Epping to Thornleigh Third Track Proposal. Application number SSI 5132.

I/we object to the Epping to Thornleigh Third Track Proposal and consider that the EIS is inadequate and does not address the full impact of this proposal. It will cause untold damage to the health of residents and to the fabric of the Beecroft Cheltenham Heritage Conservation Area. Do not approve this project, reconsider the alternatives and protect the community.

Figure 5.6 Cross-section and elevation - New Cheltenham Station concourse building
Note: Indicatively added to future design

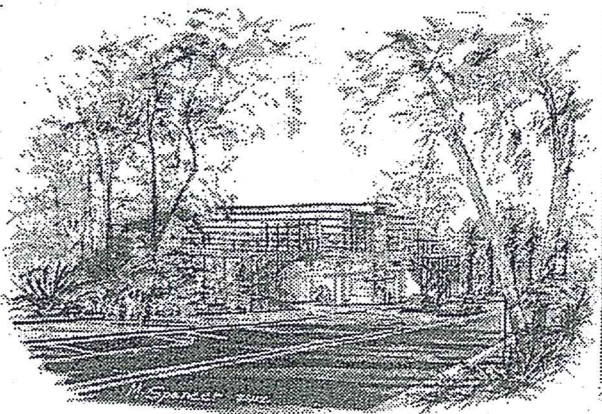
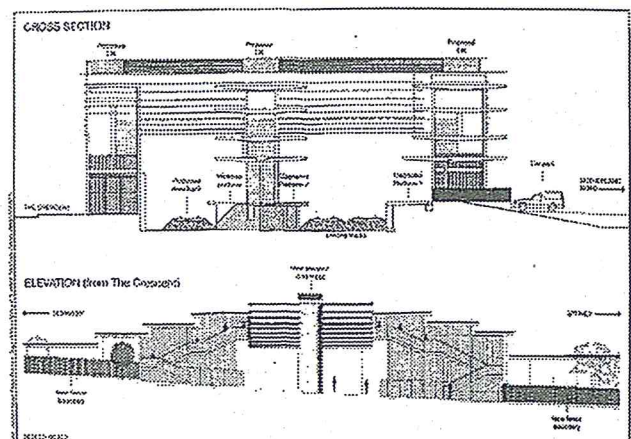
- The proposed redevelopment of Cheltenham Station shows no regard for the HCA. The visual impact of the proposed 13m high glass and steel concourse is totally unacceptable in this HCA.

Concept design drawing of proposed changes to Beecroft Station (Parsons Brinckerhoff 9/3/12). Former side platform shaded in pink.

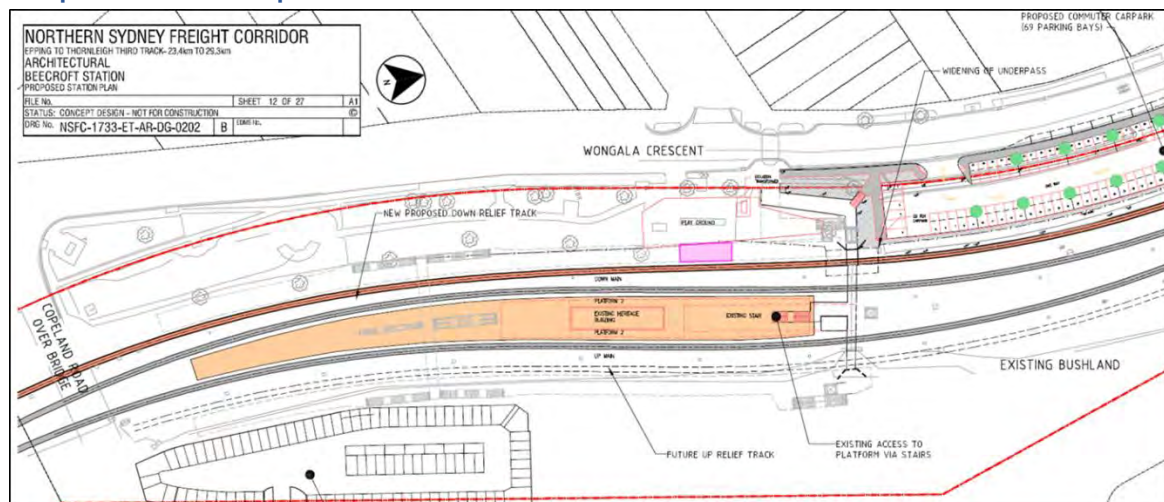
- There has been inadequate assessment of the project's impact on the fabric of the Beecroft Cheltenham Heritage Conservation Area (HCA).
- The plan given for Beecroft Railway station Precinct is vague. The relationship to the trees, playground and original 1895 platform located south of the present station is not shown. A fourth track is shown on the eastern side. The plan does not include urgently needed lifts to allow disabled access at Beecroft Station.
